SWPPP Rain Event Inspection Report

General Information			
Project Name	Top Golf Albuquerque		
NPDES Tracking No.	NMR 1001XF/NMR 1001XJ	Location	1600 Desert Surf Loop
Date of Inspection	7-26-19	Start/End Time	Overnight 7-25-19
Inspector's Name(s)	Brad Frosch		
Inspector's Title(s)	SWPPP Compliance Inspector		
Inspector's Contact Information	bfrosch@tierrawestllc.com 505-263-5808		
Inspector's Qualifications	Qualified SWPPP Preparer and Inspector of Stormwater Controls		
Weather Information			
Has there been a storm event since the last inspection? <input checked="" type="checkbox"/> Yes <input type="checkbox"/> No Reporting Weather Station- Albuquerque International Airport Storm Start Date & Time: 7-25-19 Storm Duration (hrs): 5 Approximate Amount of Precipitation (in): 1.05 Site rain gauge recorded 1.5"			
Weather at time of this inspection? <input checked="" type="checkbox"/> Clear <input type="checkbox"/> Cloudy <input checked="" type="checkbox"/> Rain <input type="checkbox"/> Snowing <input type="checkbox"/> High Winds <input type="checkbox"/> Other: Temperature: 78° F

SEDIMENTATION/SILT FENCE WITH WIRE SUPPORT

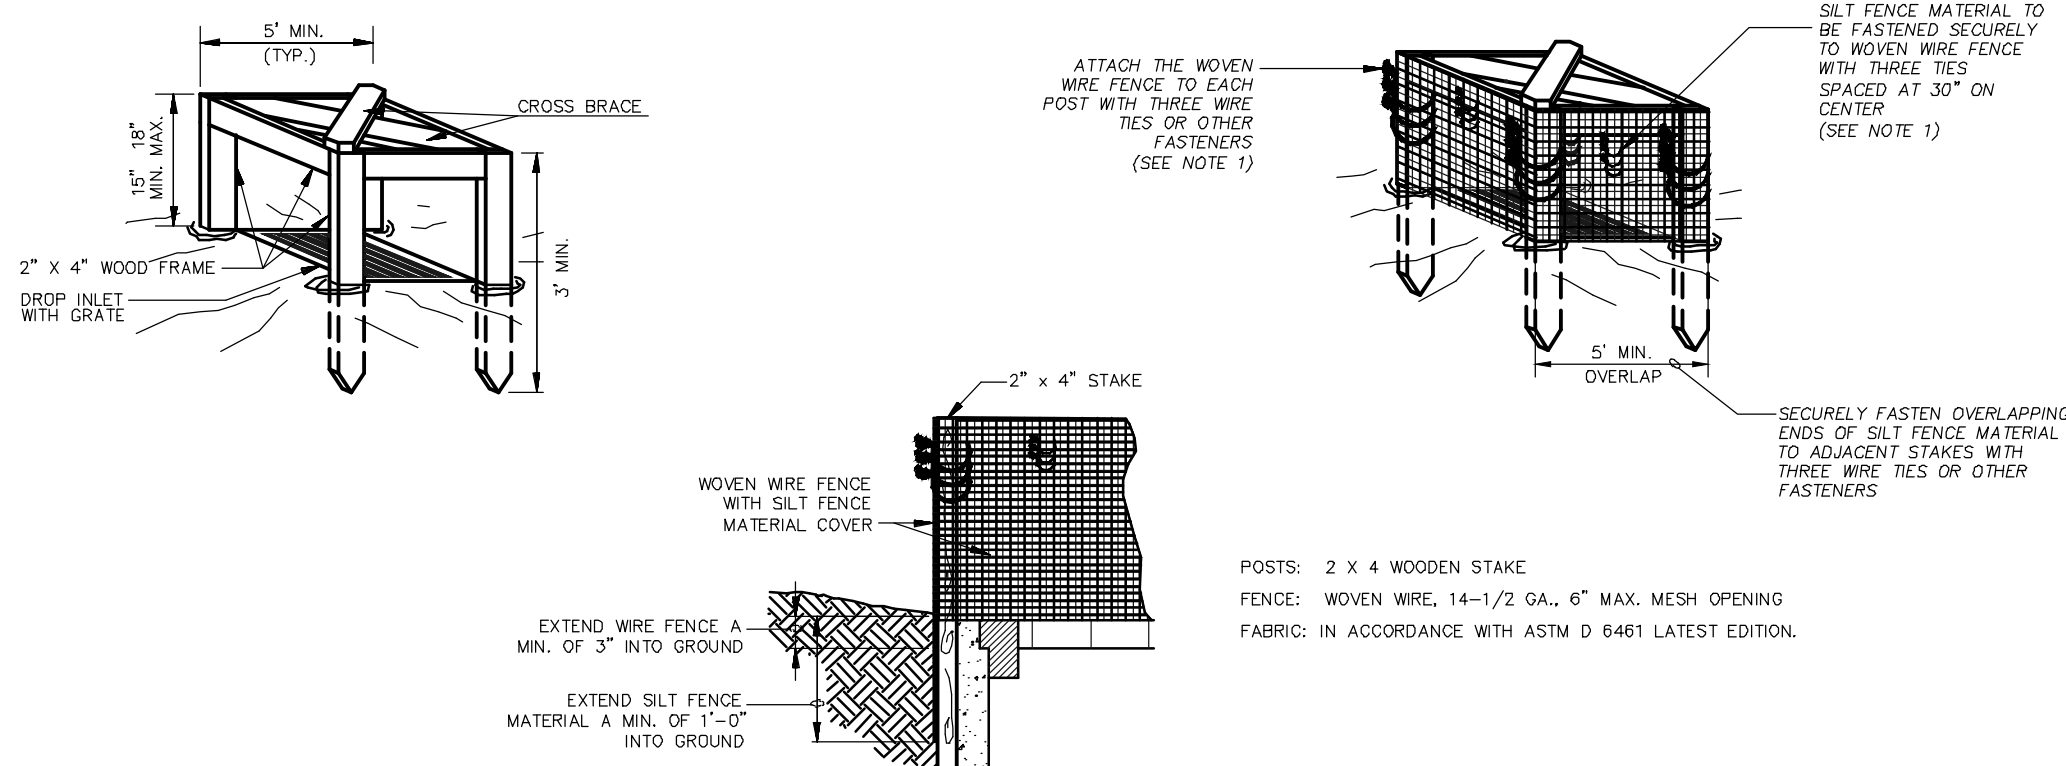
Silt fencing recently installed at NMDOT inlet is not keyed into substrate. A diversion berm or other should be placed to direct offsite flows towards NMDOT inlet.

Perimeter silt fencing should have sediment removed where sediment exceeds 50% capacity to insure proper retainage of sediment and filtration of runoff. Sediment is present at City sidewalk on Desert Surf and remains to be cleared. Desert Surf inlets need to be cleared of sediment and controls replaced. Grading has removed north entrance sediment traps and new traps should be installed out of proposed work area.
